Case Officer: Susan Haley
Telephone: 01903 737694
Email: susan.haley@arun.gov.uk

Application No: EP/68/26/HH
Site Address: 8 Tamarisk Way East Preston BN16 2TF
Description of works: Two storey front extension. New windows. New cladding to the first floor.

Drawing Name:
Proposed Roof Plan

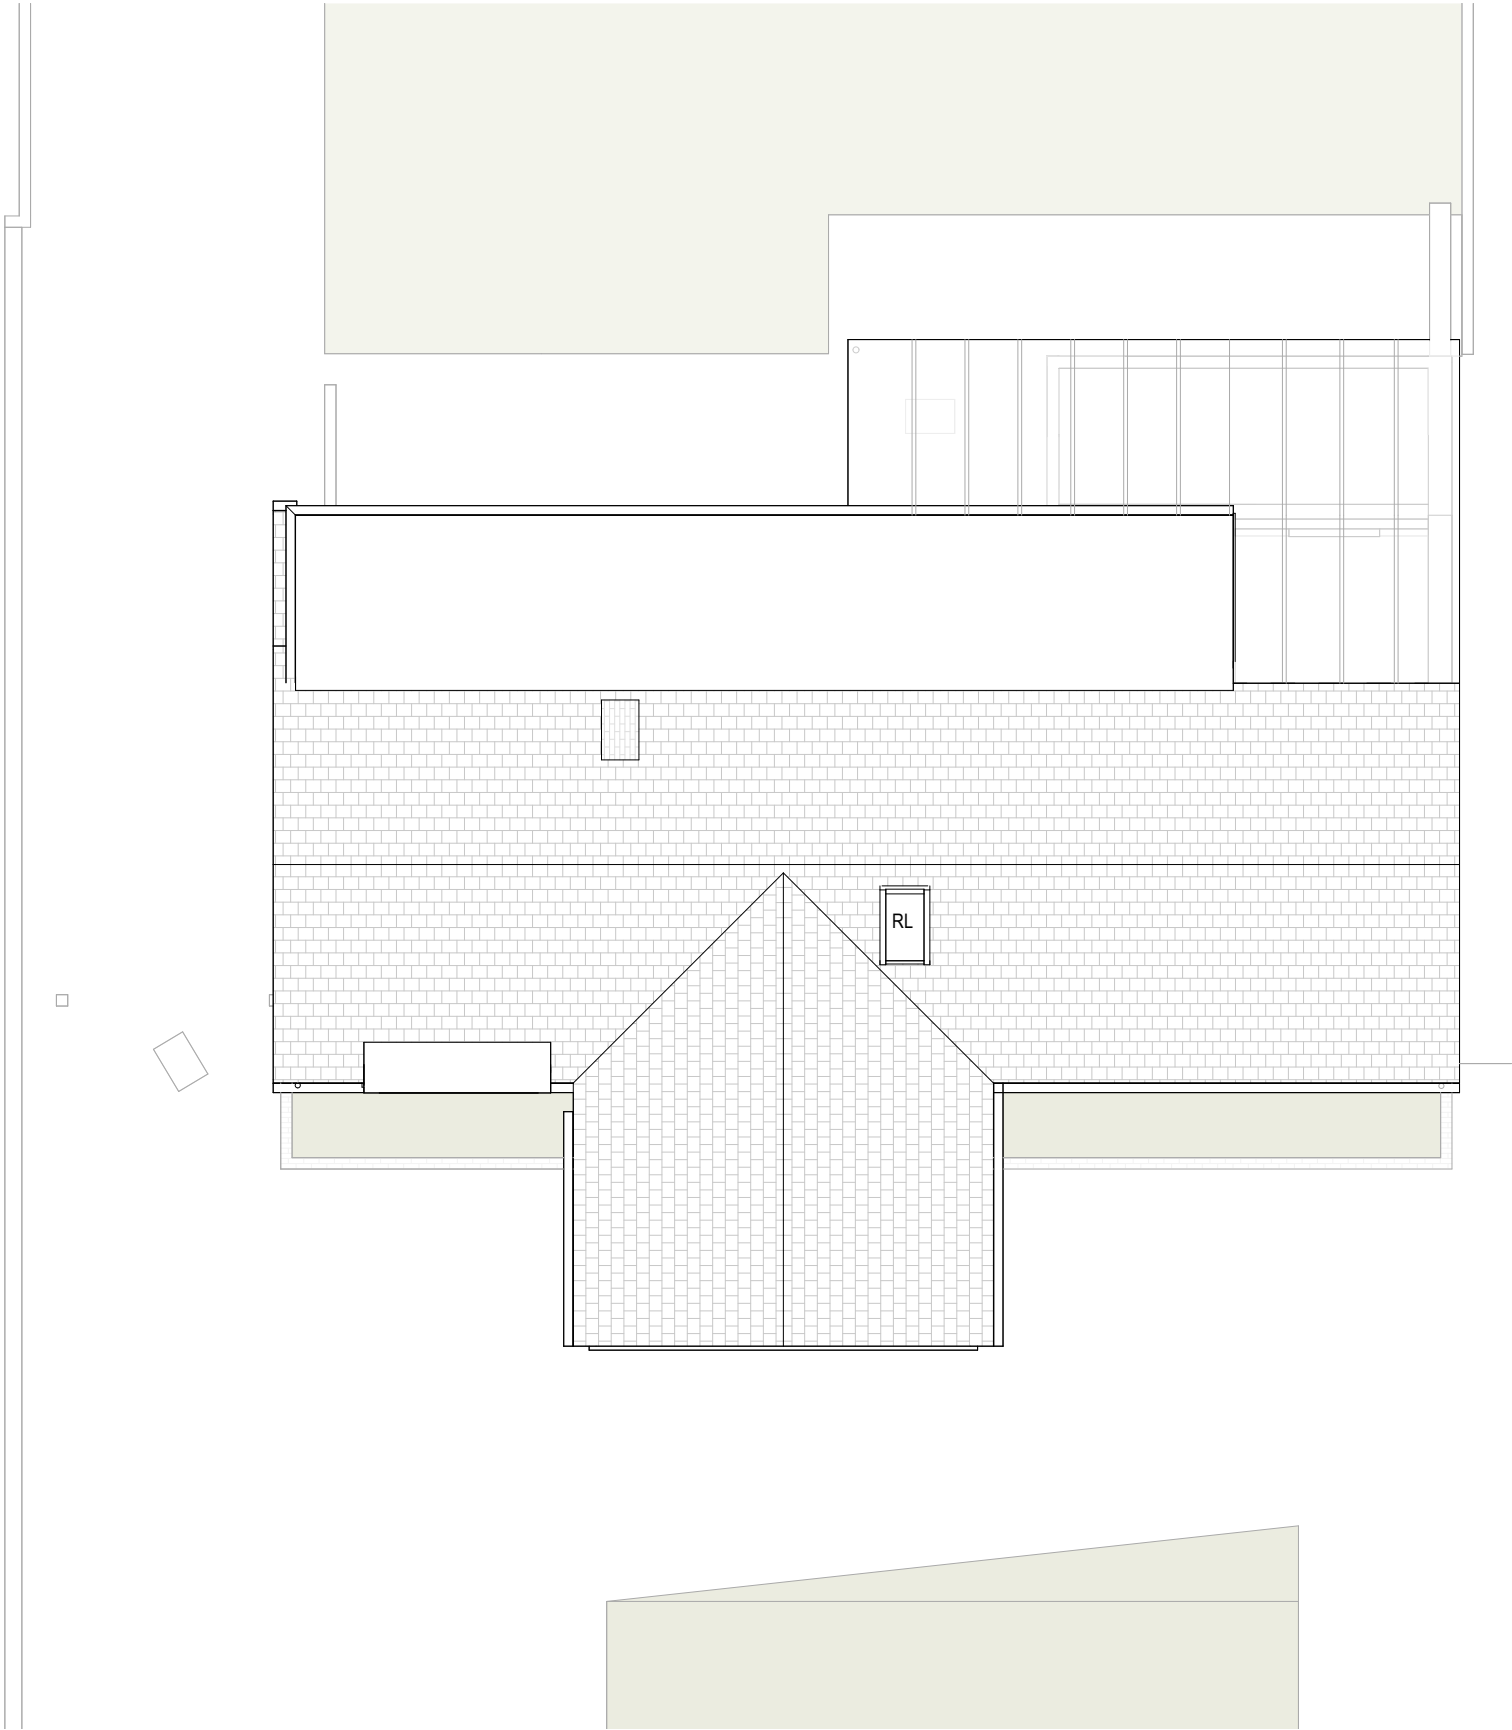
The committee did express concerns there were no details of the roof tiles colour nor of the balcony railings.
